Zoe Deiches
Corner Cottage, 125 Sea Road, East Preston BN16 1NX

Ref: Planning Application EP/40/12. Substitute Plans 3279/P200 – 3279/P201.

I am writing to object to the planning application EP/40/12. Substitute Plans 3279/P200 – 3279/P201.

number: 3279/P201 rev: D  
dm: agw chkd: ge appd: ge

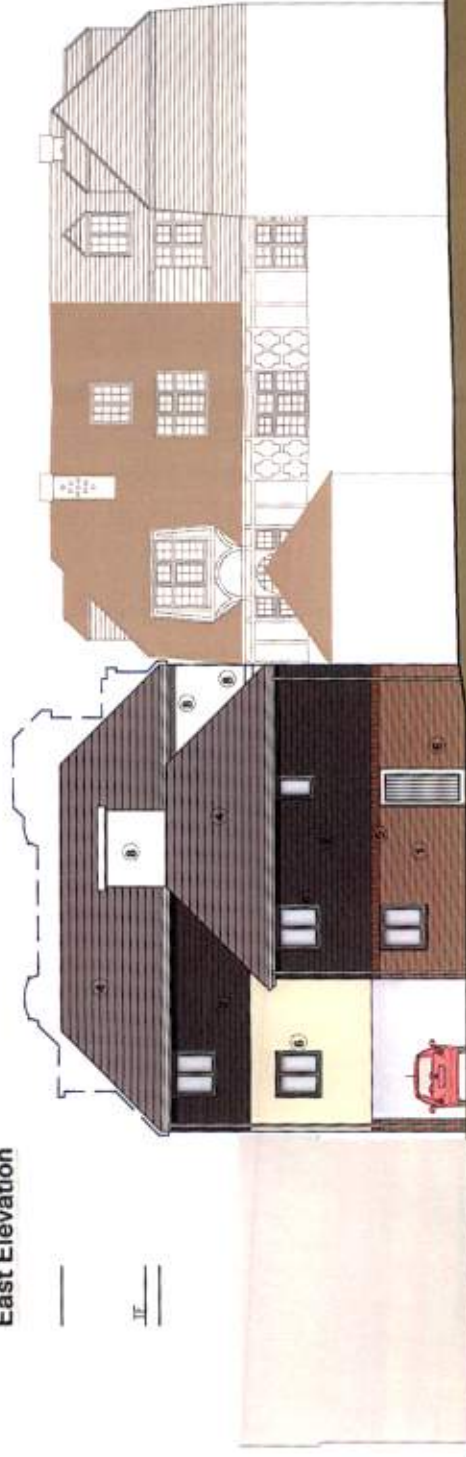
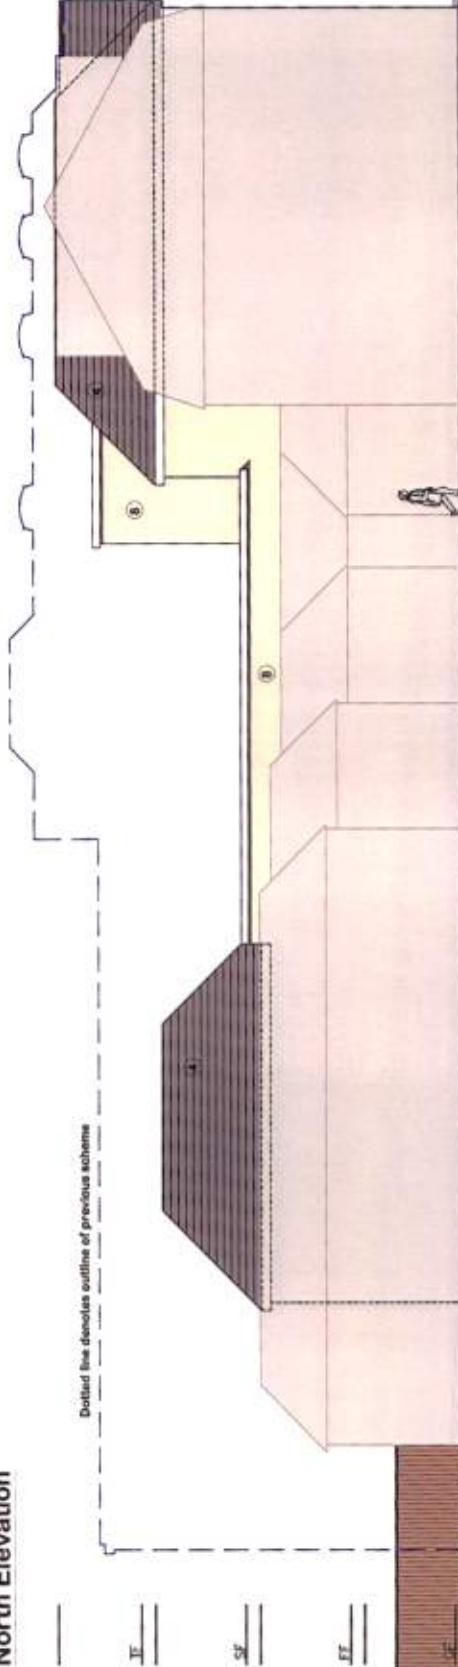
The proposed development is not an extension / replacement within a reasonable extension of dimensions in height or width of the existing structure.

The building is not in keeping with the buildings in the surrounding area where a series of Georgian cottages are the most attractive and some of the oldest remaining structures.
